SHOALHAVEN STARCHES PTY LTD  
36  
BOLONG ROAD  
BOMADERRY 2541

22/10/2020

Shoalhaven Starches Expansion Project Modification 19 (06\_0228 Mod-19)  
**Request for Additional Information**

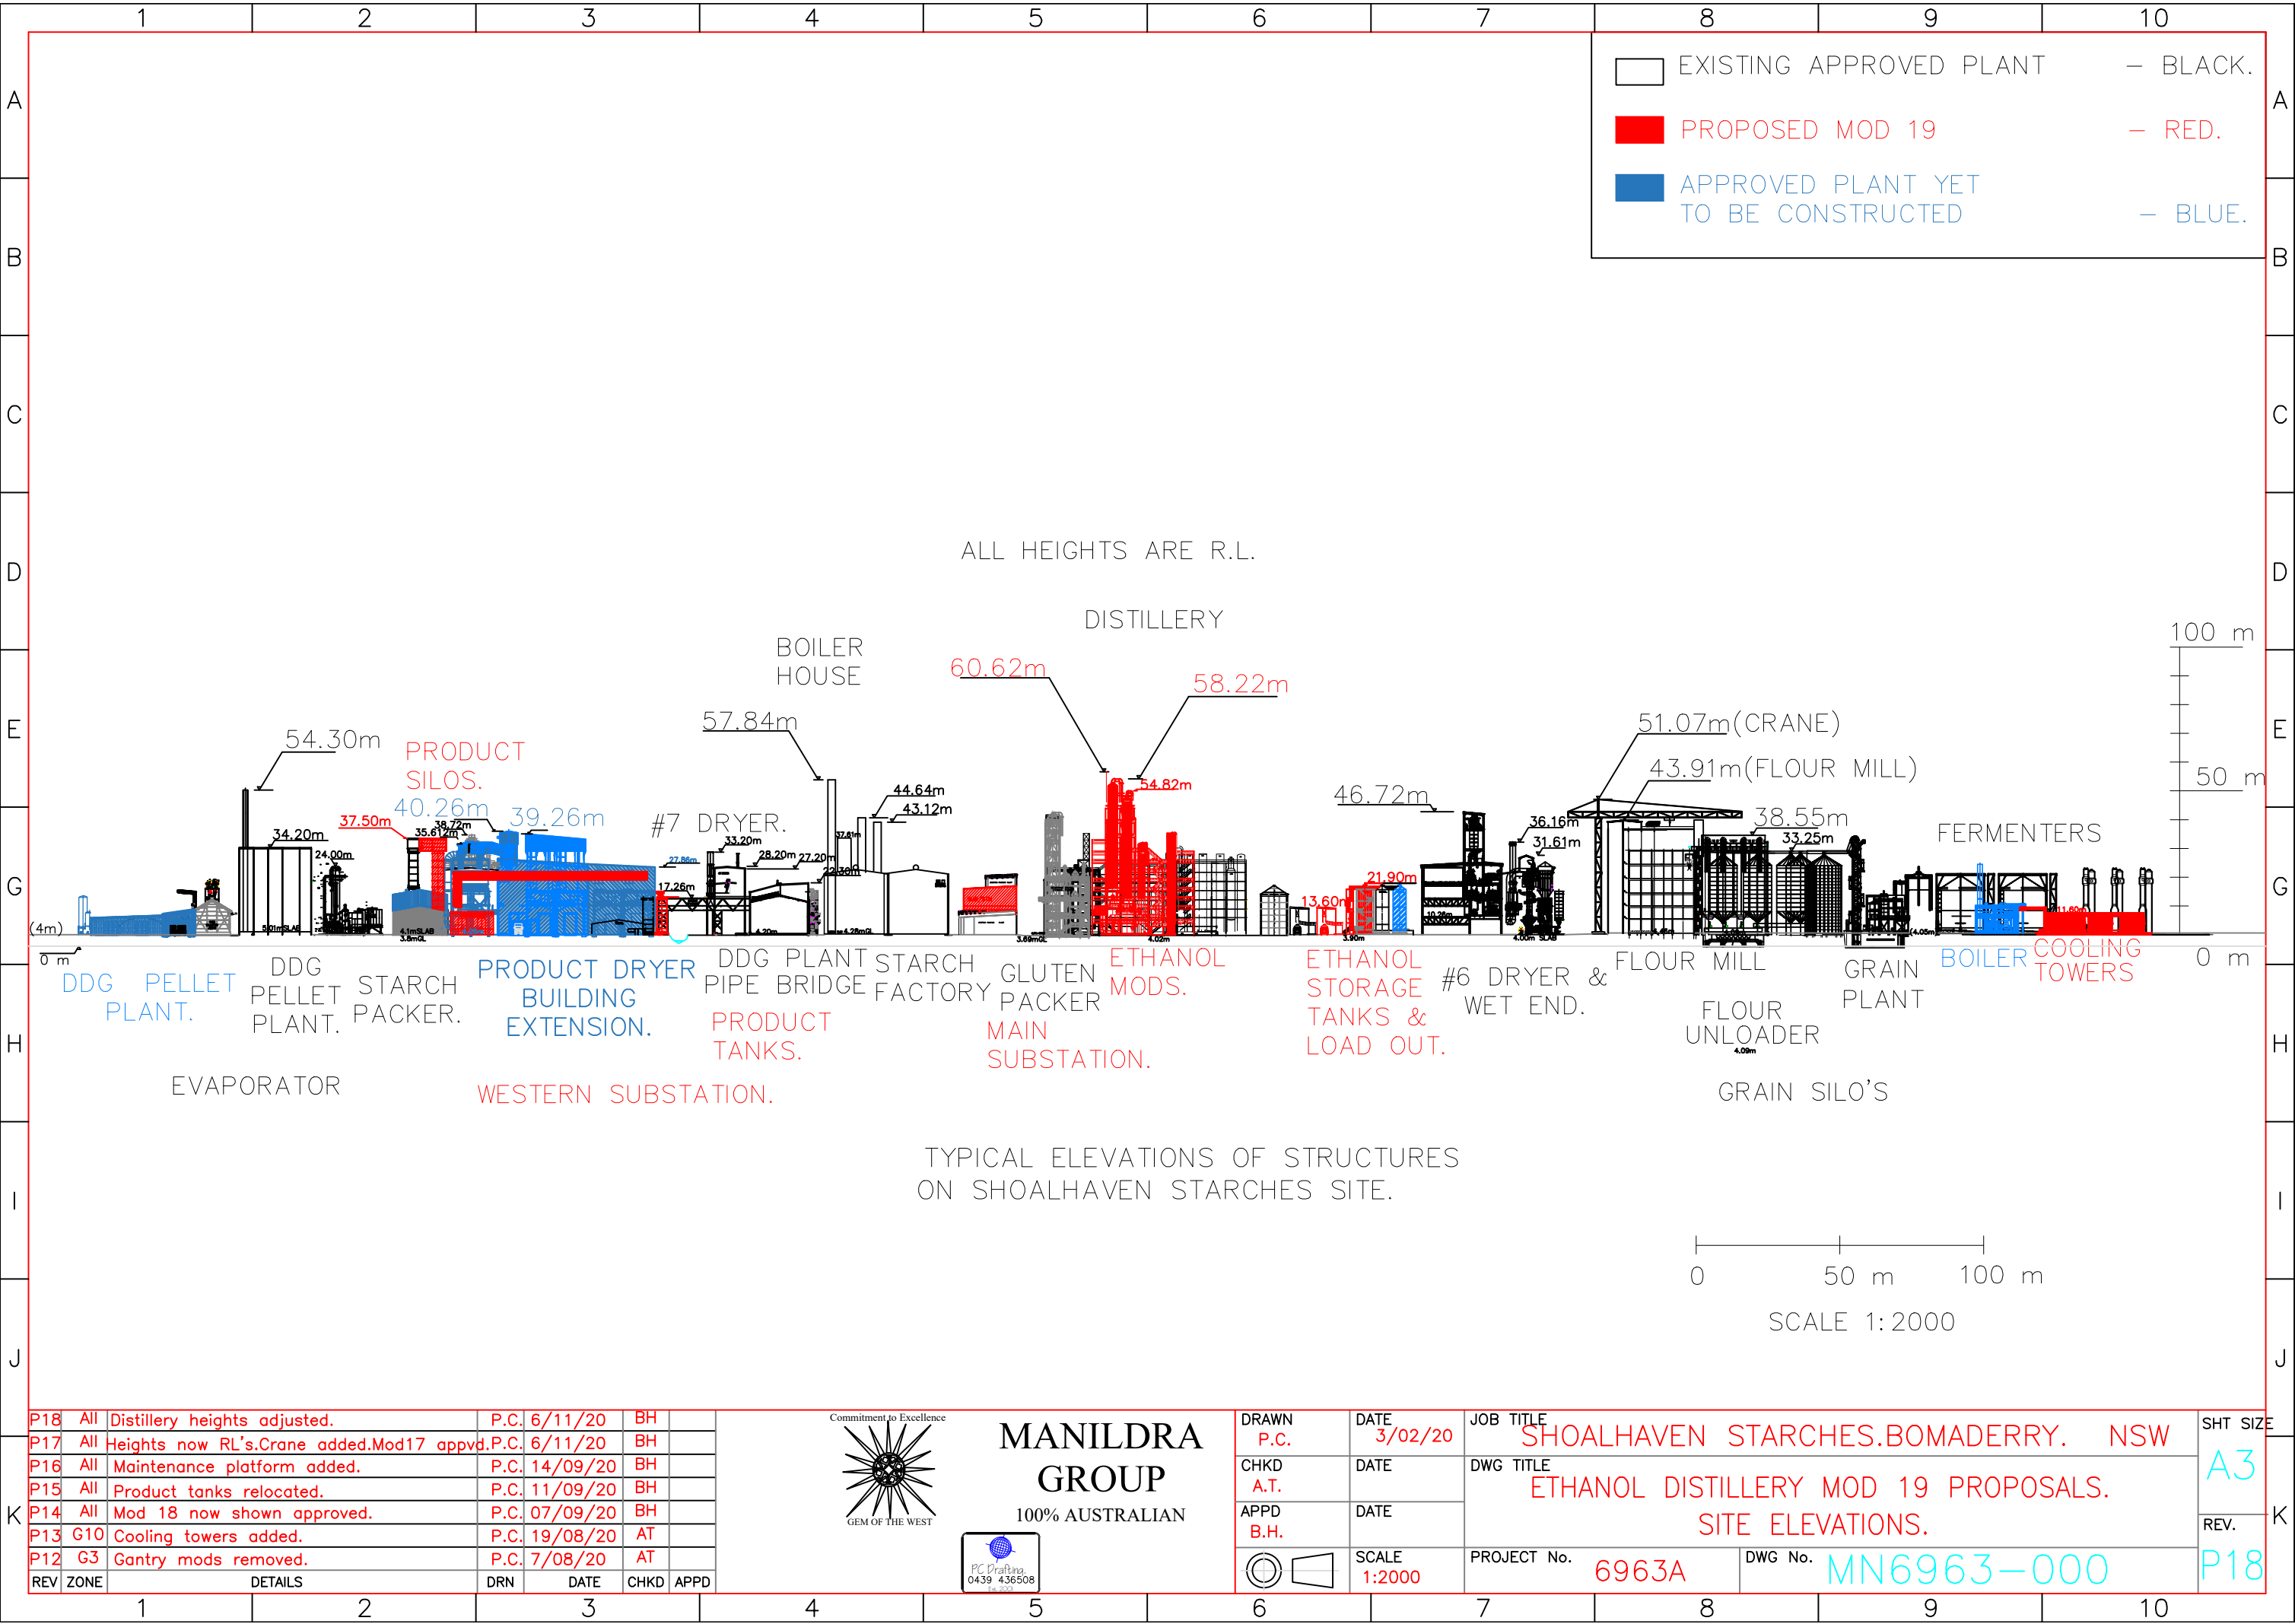
4. The SEE identifies the proposed new distillery columns will have a maximum building height of 54 metres (m) but would not exceed the existing tallest site infrastructure. However, the SEE identifies the tallest existing site infrastructure to be the boiler house stack at 53.7 m, being less than the proposed new distillery column. The Department requests further clarification on the maximum height of existing site structures. If the proposed new distillery column is higher than all existing site infrastructure, further justification is required for the proposed height and the associated visual impacts arising from the modification.
